CITY OF ALBUQUE

**Re: Avid Hotel – 1441 Woodward Rd SE
Erosion and Sediment Control Plan
Engineer's Stamp Date 5/25/2022 (M15E023B)**

LS-1
4/30/2021

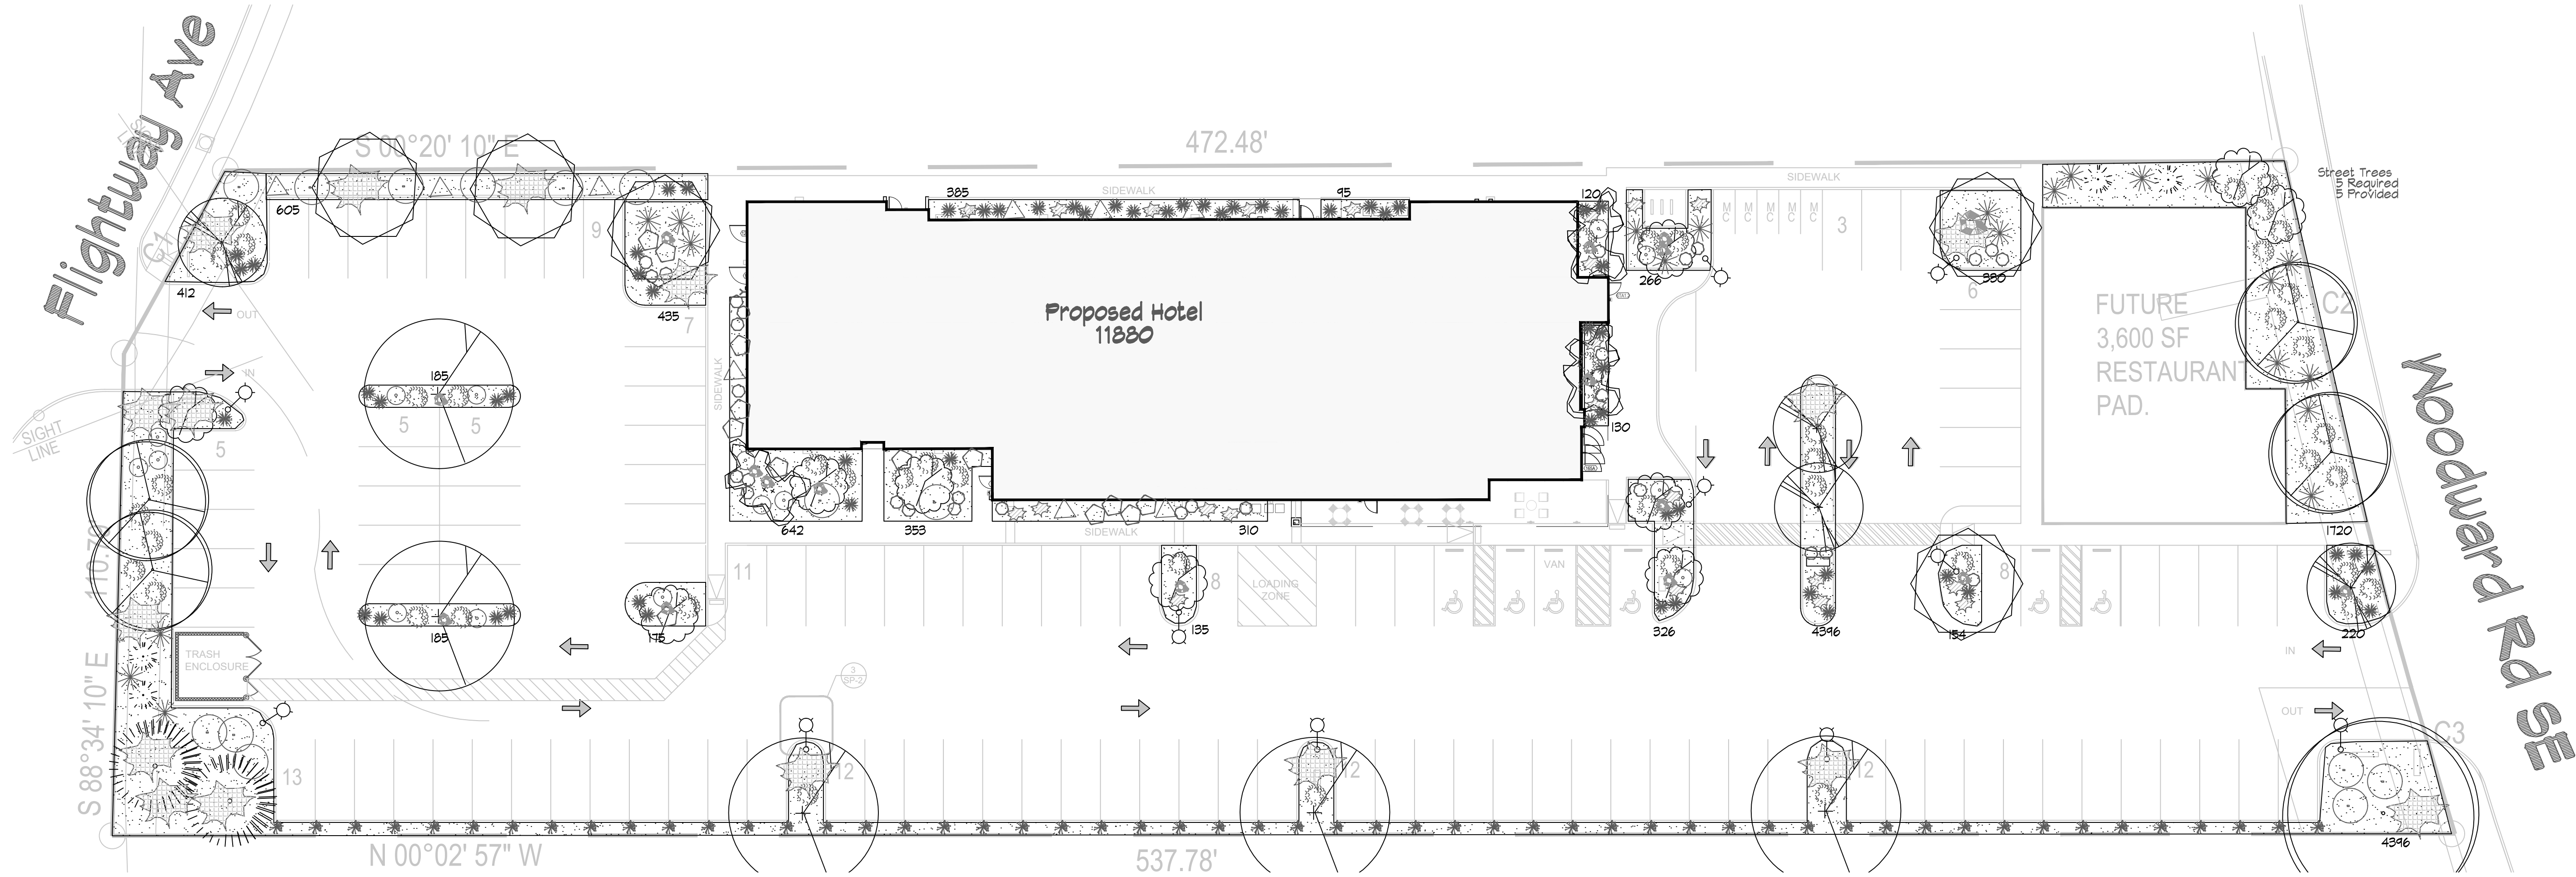
2. The SWPPP must include site-specific interim and permanent stabilization per CGP 9.4.1.c.i. The Landscape Plan can be used to satisfy this requirement and should be submitted separate from the ESC Plan with the application to the Stormwater Quality Section of the Planning Department and they should be included in the SWPPP.

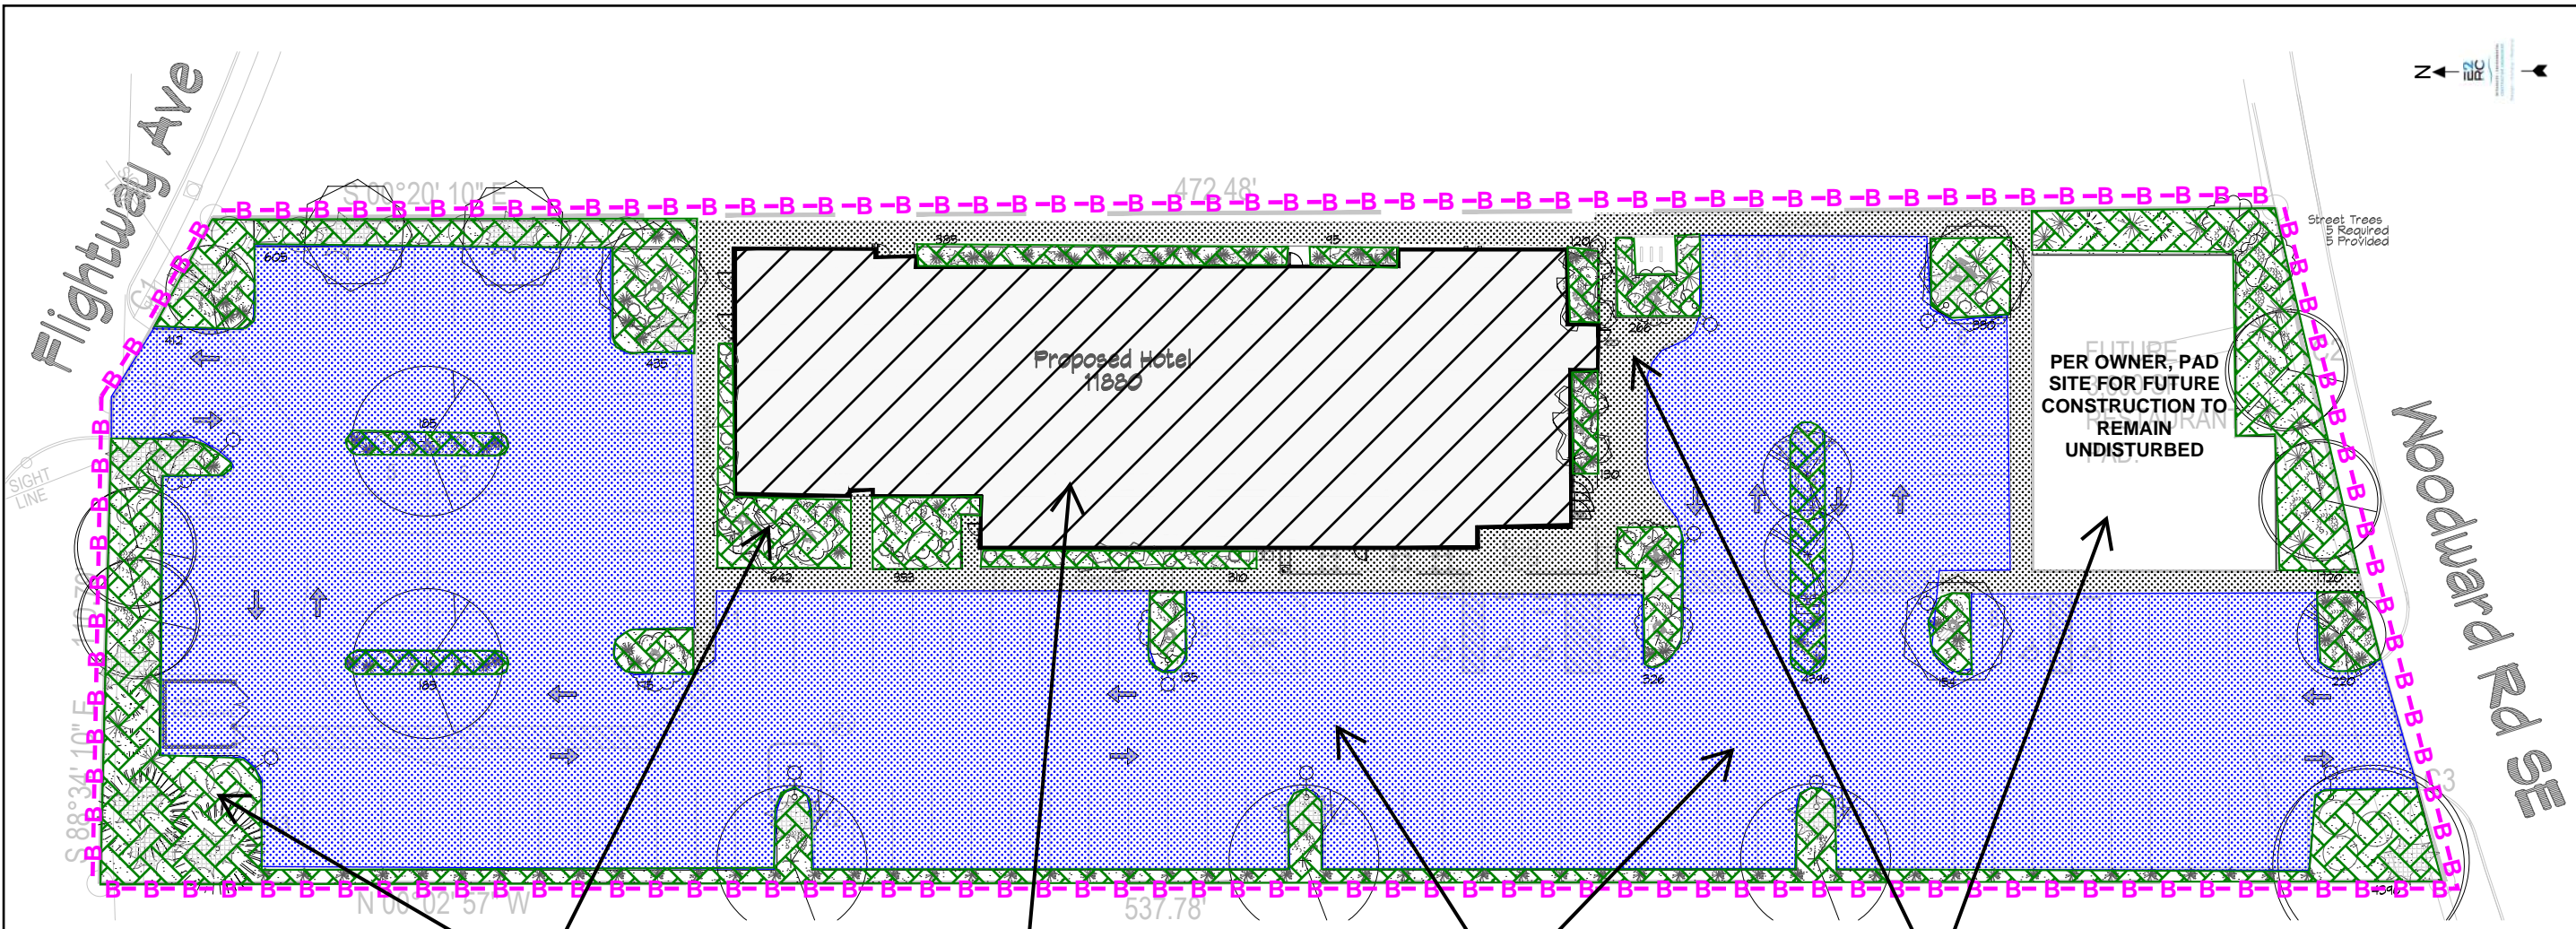
4. Structures must be clearly identified in the SWPPP per CGP 7.2.4.b.vi. The same information is required in the ESC Application. Provide a copy a copy of the Site Plan and make sure that sheet 9 os the SWPPP map agrees especially at the future pad.
